Recommendation Report

EG/25/13.

SUBJECT: EG/25/13-Provision of a drop kerb.

1 Hall Cottages, Barnham Road, Eastergate, West Sussex, PO20 3RS

SITE PLAN

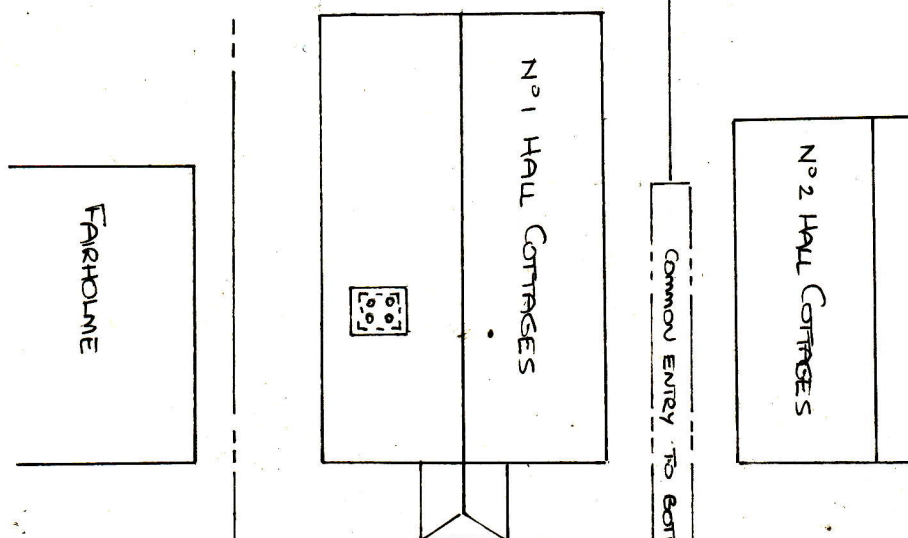
The proposed crossover to access the driveway will require visibility splays of 2m for pedestrians, shown on the proposed plans; this will require any proposed planting to be no higher than 0.6m above the ground level and any existing foliage to be maintained in order to safeguard the visibility splay.

Vehicular visibility splays of 2.4 by 43 metres have been shown on the submitted plan and appear to be achievable. A licence from the WSCC local Community Highway Officer will be required prior to any access works taking place.

A turn on site would be preferred, clearly though there is insufficient space to achieve this. However other properties have similar arrangements and balanced against this is the benefit of providing an opportunity to remove a vehicle that could otherwise be parked on the highway in a location where there can be on-street parking by residents of adjoining properties. This would result in a noticeable narrowing of the existing available carriageway space.

If the LPA are minded to approve this application a condition securing the new access, pedestrian and vehicle splays should be included.
